## DECISION DELEGATED TO HEAD OF PLANNING

Application No:	H18-0622-25	Applicant:	Enso Green Holdings R Limited
Proposal:	Installation of a solar farm and battery storage facility with associated infrastructure - approved under H18-1034-23 (original permission H18-0741-21). Modification of Condition 2 to allow amendments to previously approved plans - approved under H18-0448-24. Modification of Condition 6 (Construction Traffic Management Plan and Method Statement) (CTMP&MS), modification of condition 7 relating to access onto Gunthorpe Road and removal of condition 8 relating to improvements to crossroads of King John Bank/Marsh Road/Gunthorpe Road.		
Location:	Gunthorpe Road Solar Farm Land South Of Gunthorpe Road Walpole Marsh		
Terminal Date:	8th October 2025

SCALE: 1:500	DATE: 13.04.21	DRAWN: SG	CHECKED: RR	APPROVED: JD
JOB NO: 2102-022		DRAWING NO: SK 01		REVISION: D

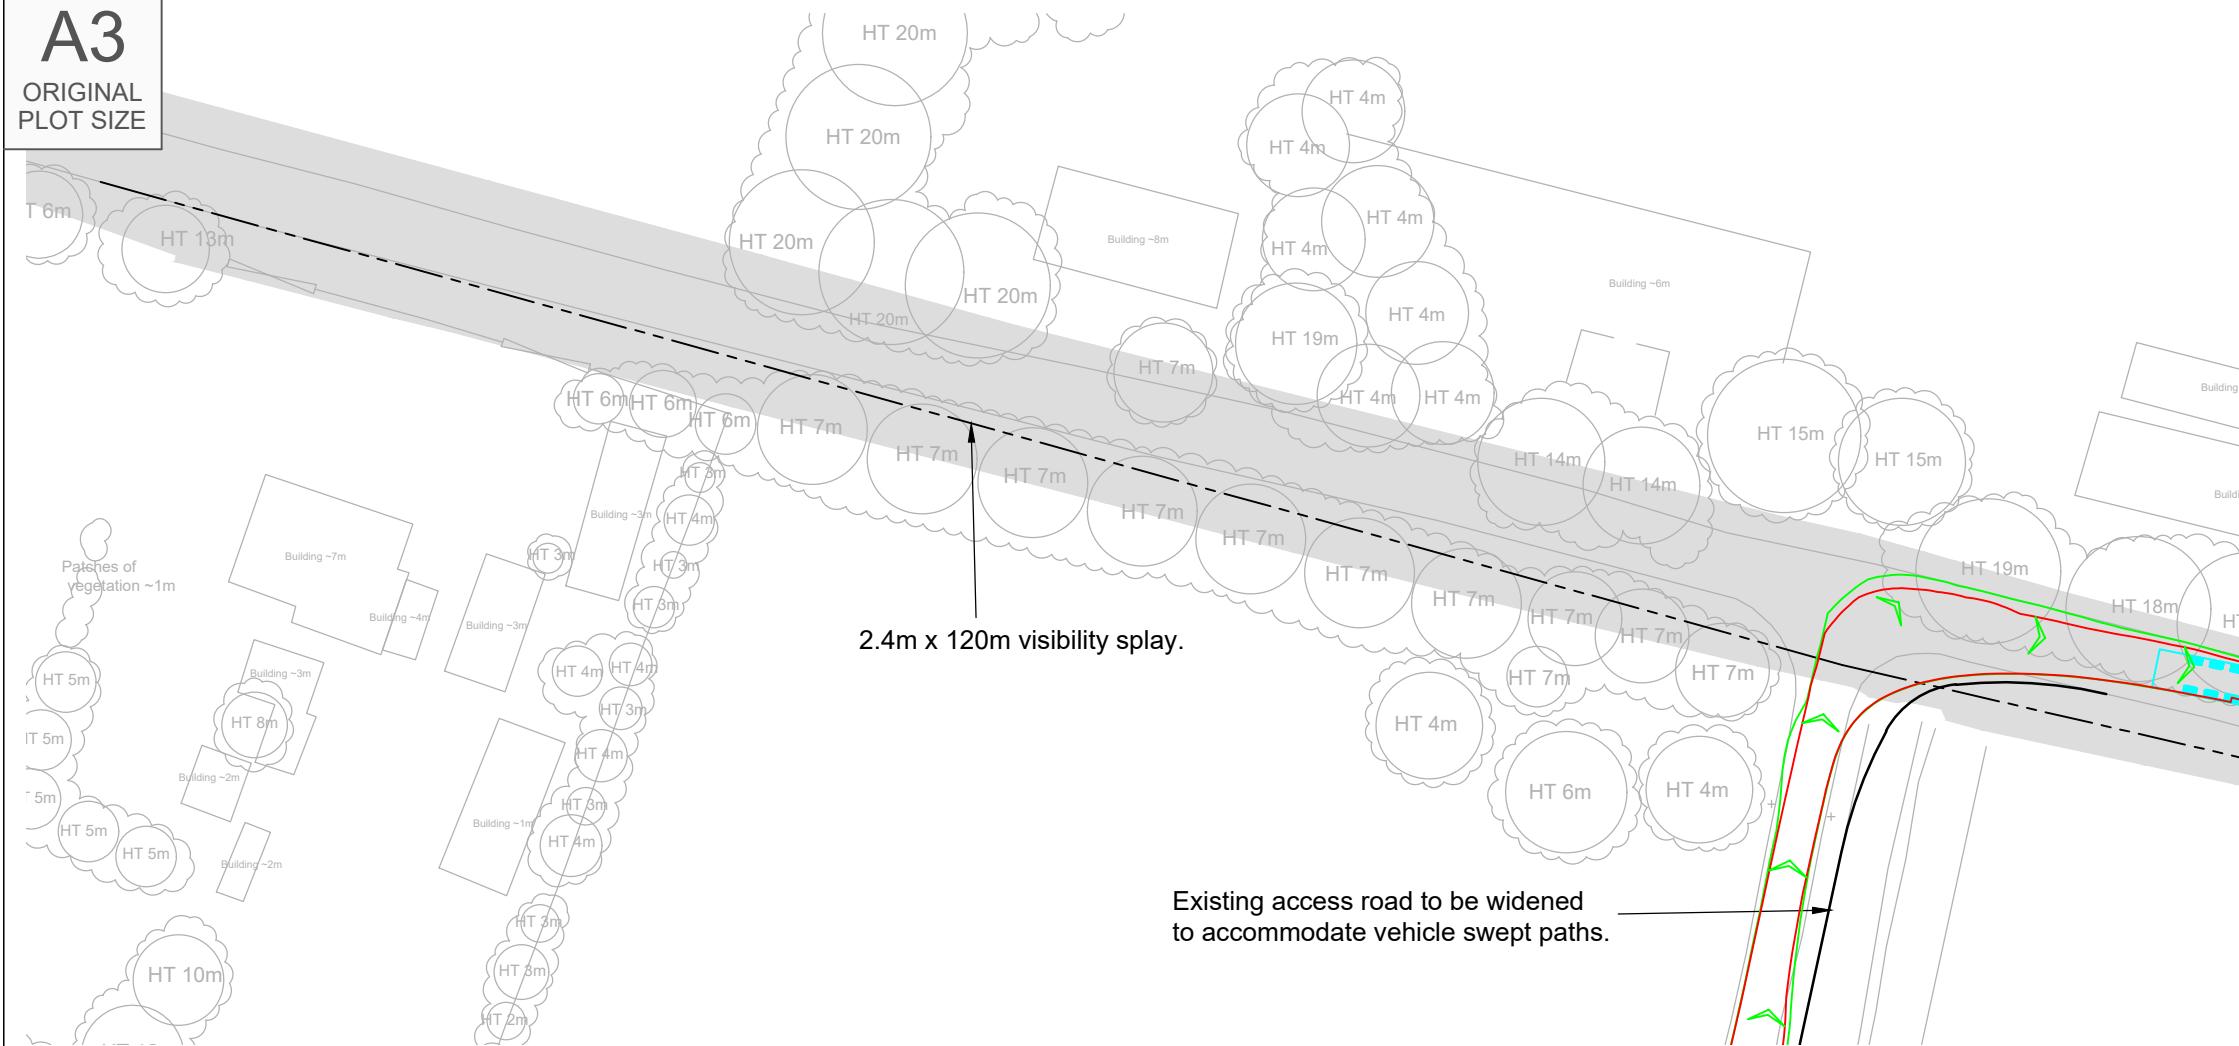
It would appear from the proposed wording that the applicant still intends to widen and remove vegetation of the access in accordance with drawing number SK01 Rev D; however, proposed site plan WP2-01-P44 does not show this access on plan, this needs more clarification. This variation is not supported
